Planning Act 2008 (as amended) – Section 51

Application by Gate Burton Energy Park Ltd for an Order Granting Development Consent for the Gate Burton Energy Park.

Advice following issue of decision to accept the application for examination

EN010131/APP/5.2  
LCA-2021-01-GateBurton  
Works Plans: Sheet 01

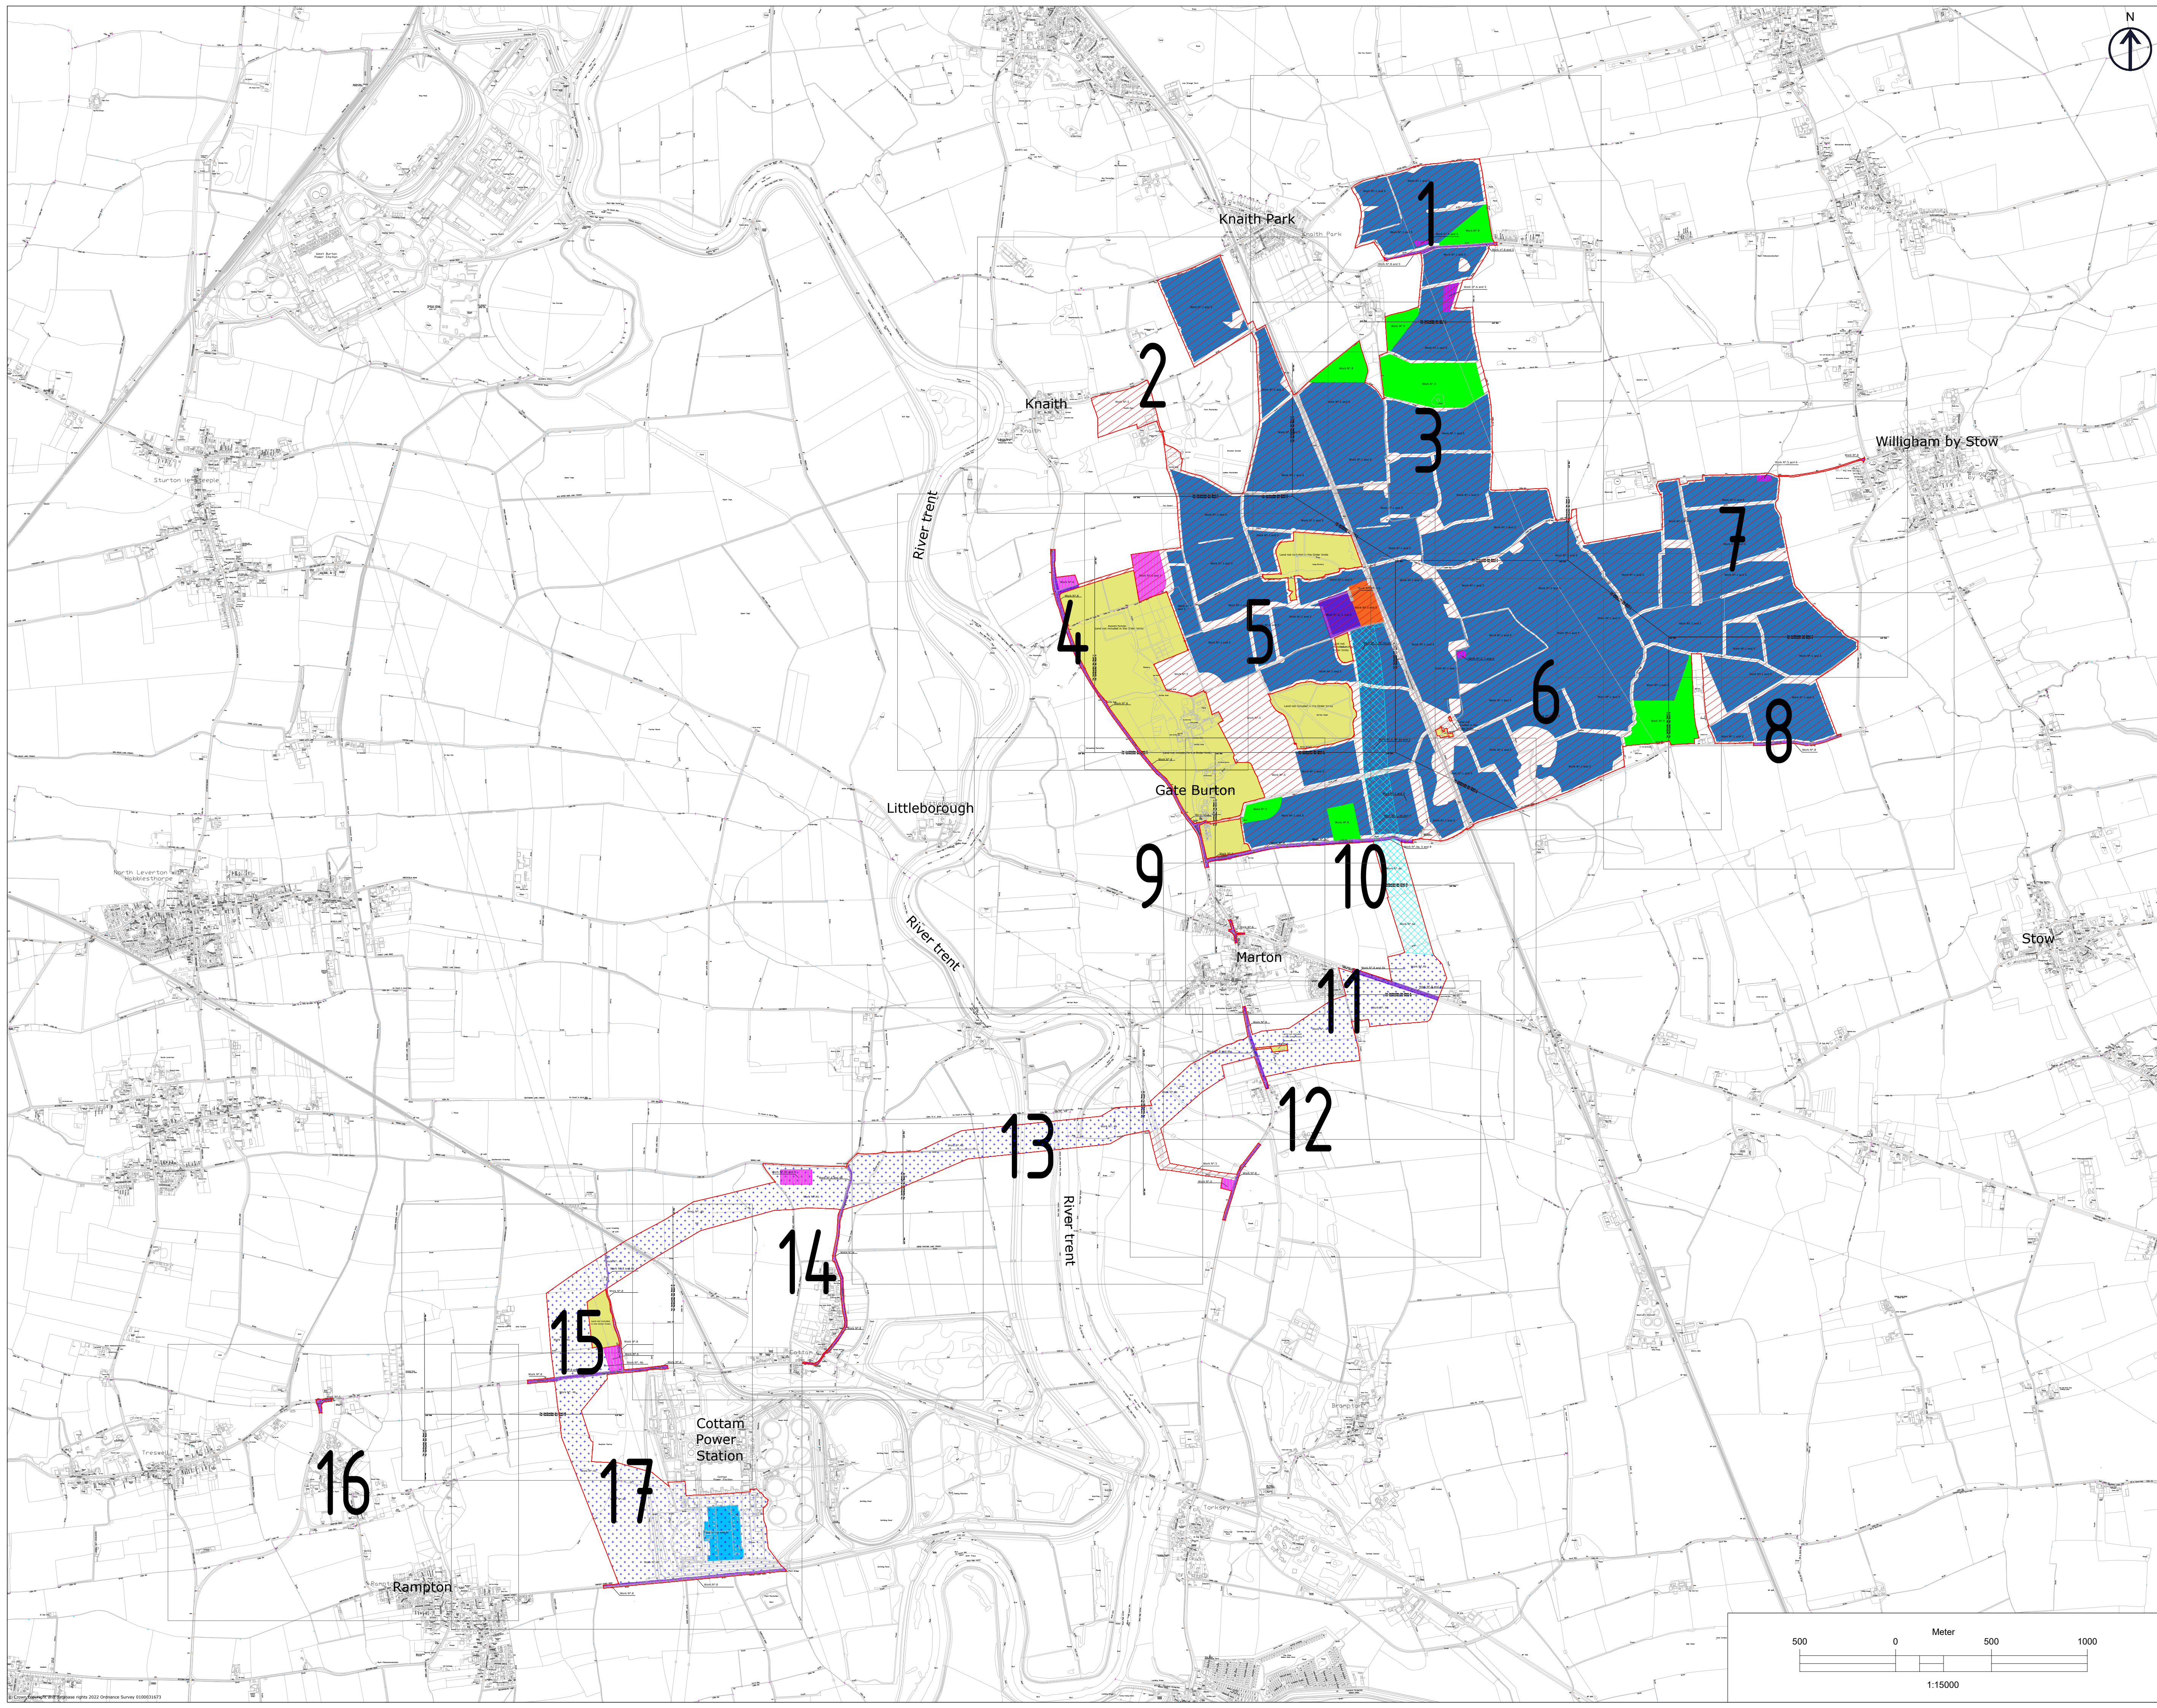
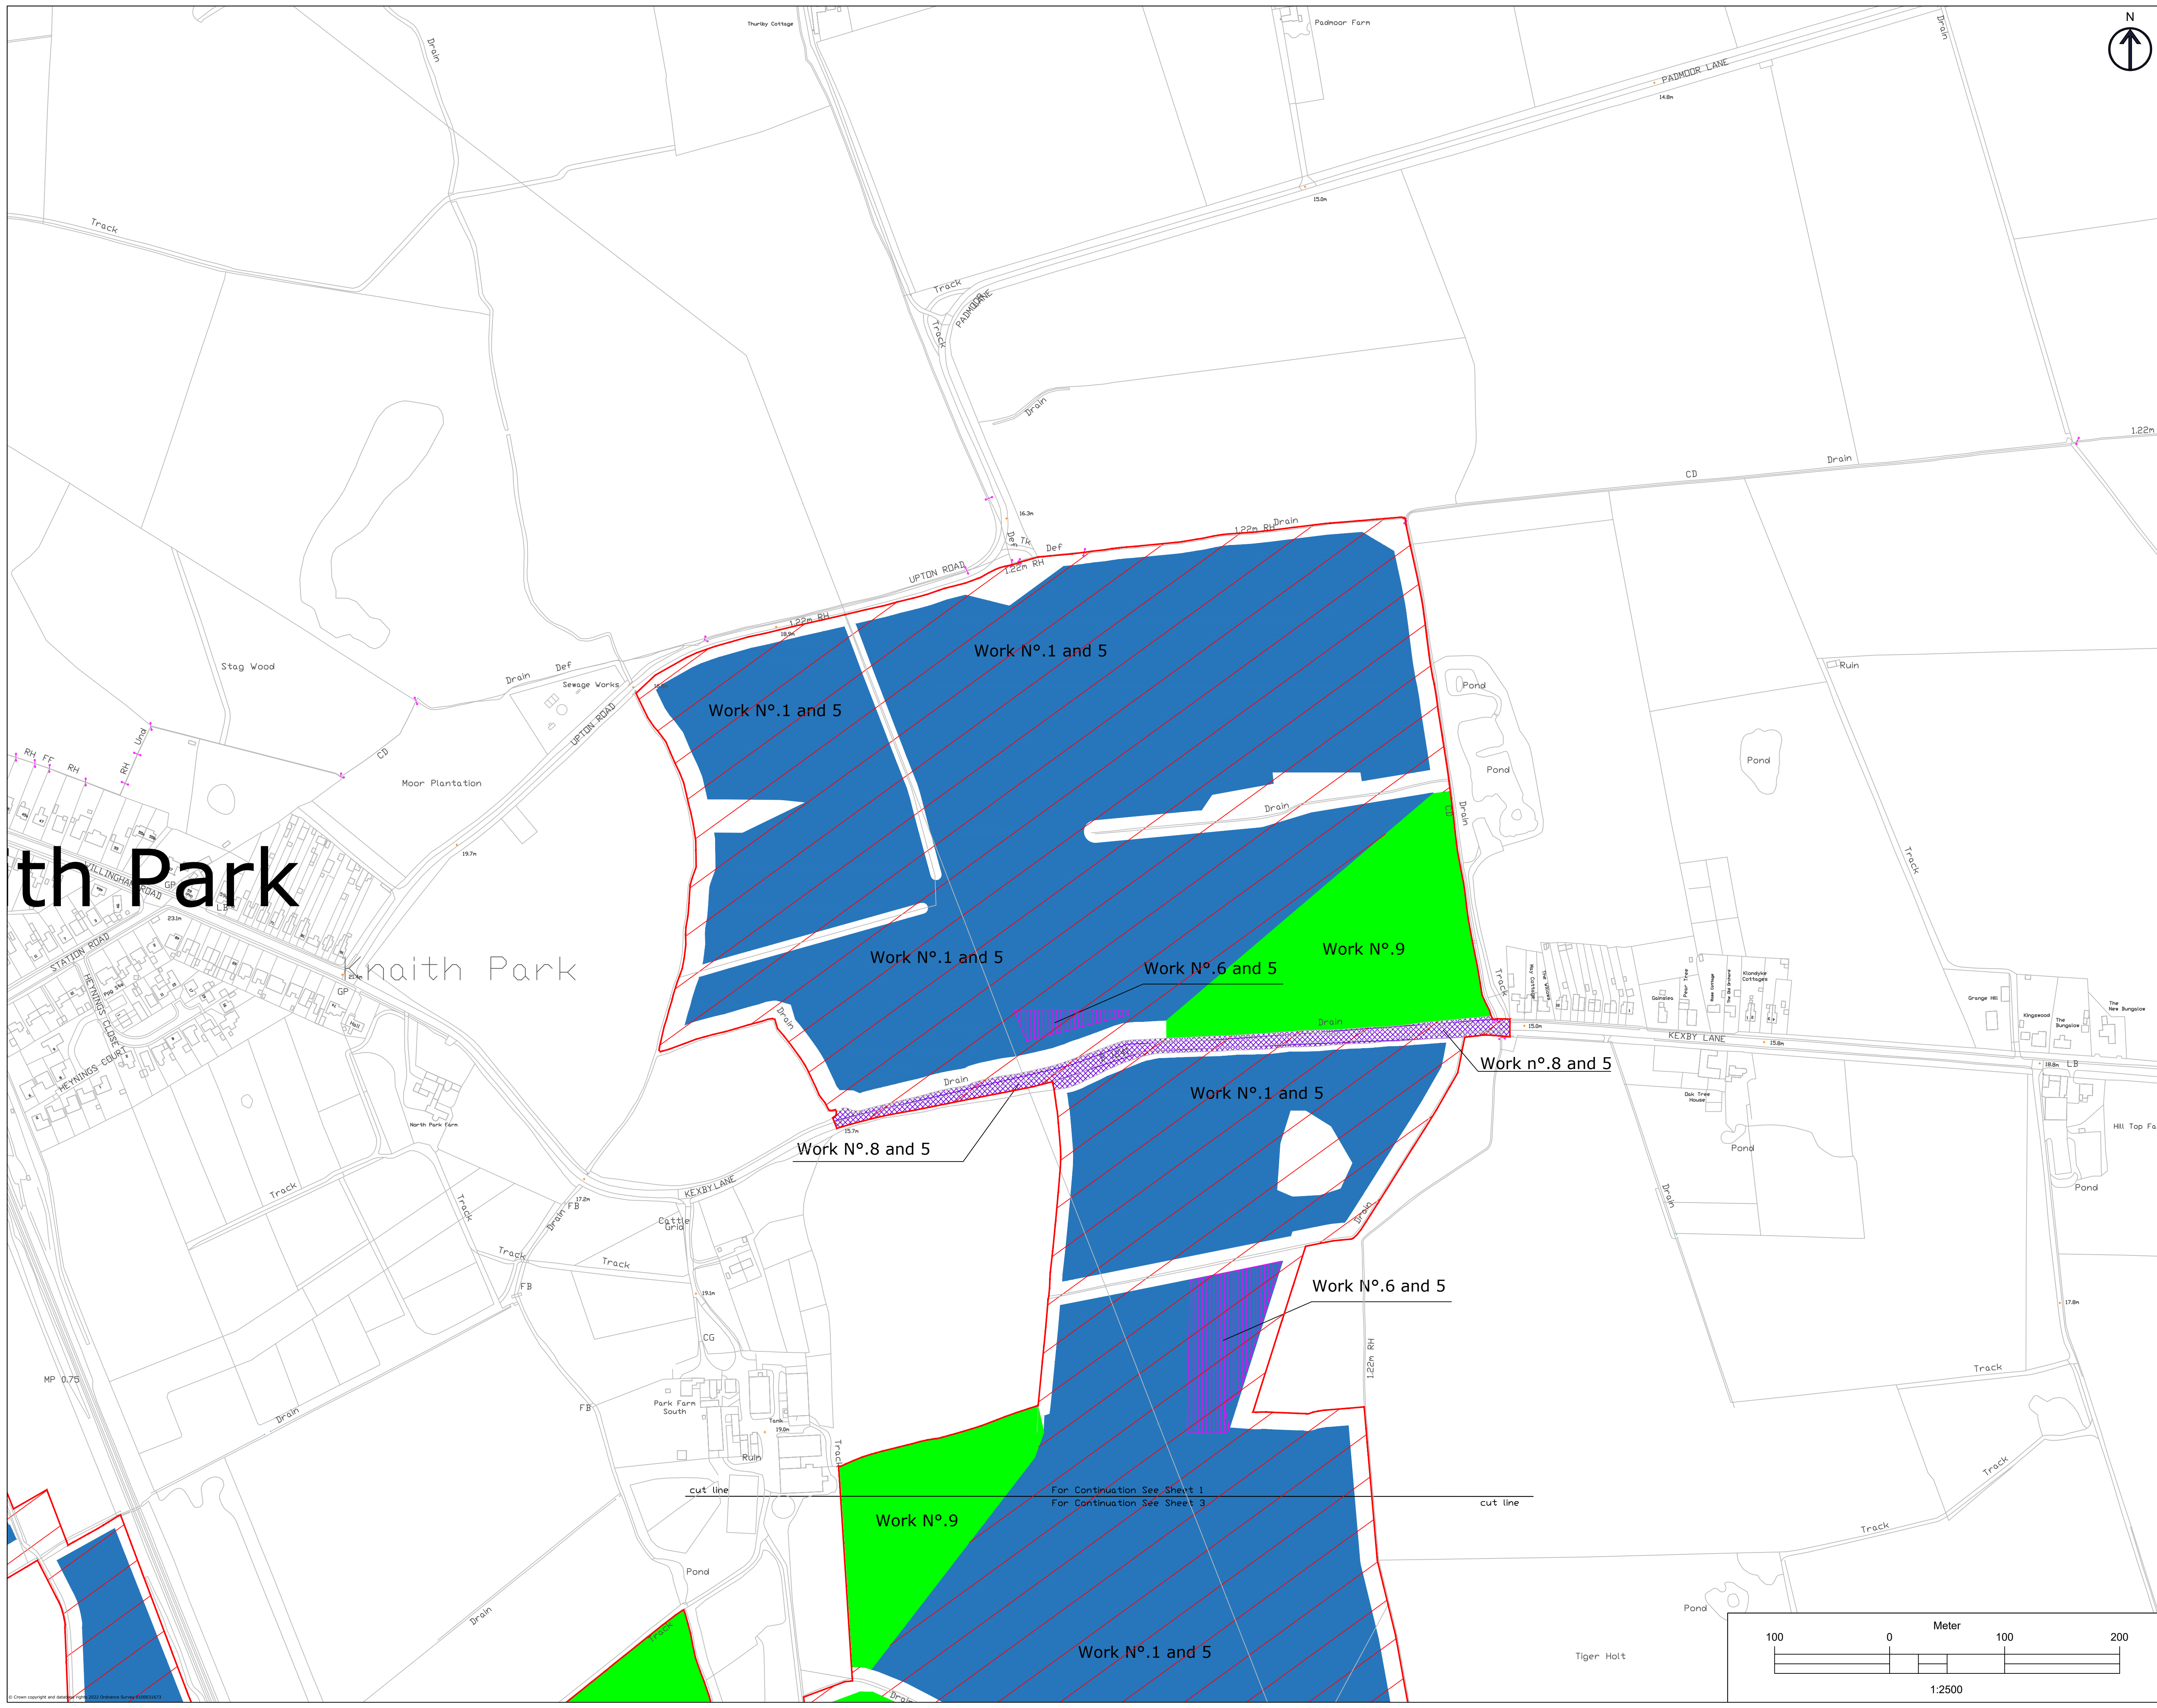
The Applicant is advised to conduct a consistency check between the Legend and the plan. For example, alphanumeric annotation is used on Works Plan but is not included in the Legend, and the colours used in the Legend do not collate well to the plan, for example, the yellow in the legend is much brighter to that used on the plan.
